MAJOR PROJECT- MP10_0195
Review of Environmental Assessment Report -
Warnervale Town Centre

Jim Tsirimiagos
Manager Land Use and Planning
RailCorp Property

6 GFA - CINEMA LEVEL
1: 1500

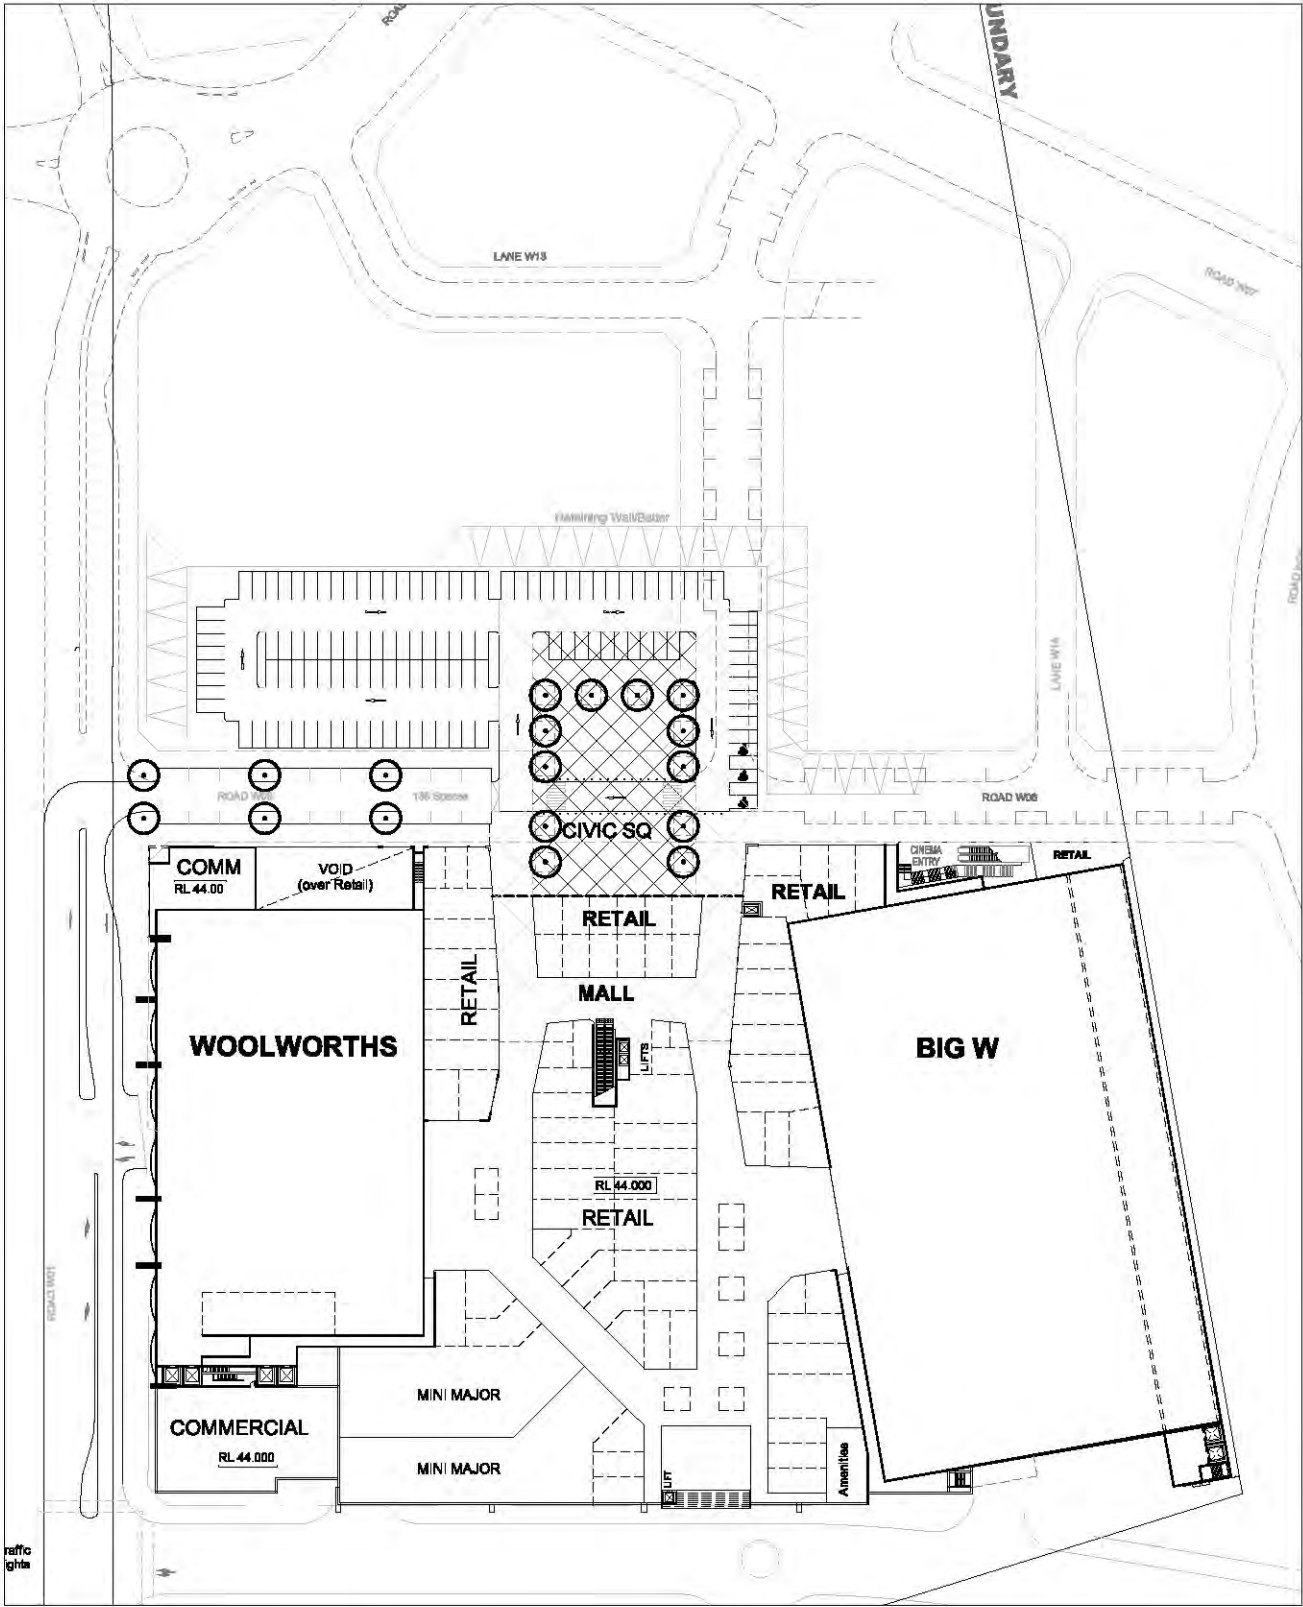
The proponent has made allowances for a total of 1880 car parking spaces for retail commercial and commuter use. The Environmental Assessment for the proposed development states that *"500 car spaces are to be provided for commuter car parking"*. However, out of the 1880 car spaces provided only 220 are identified for commuters in the transport report. RailCorp requests that the Warnervale Environmental Assessment provides an indication on the proposed location of the remaining 280 spaces for commuter car parking along with details on how these commuter spaces will be distinguished from retail and commercial spaces.
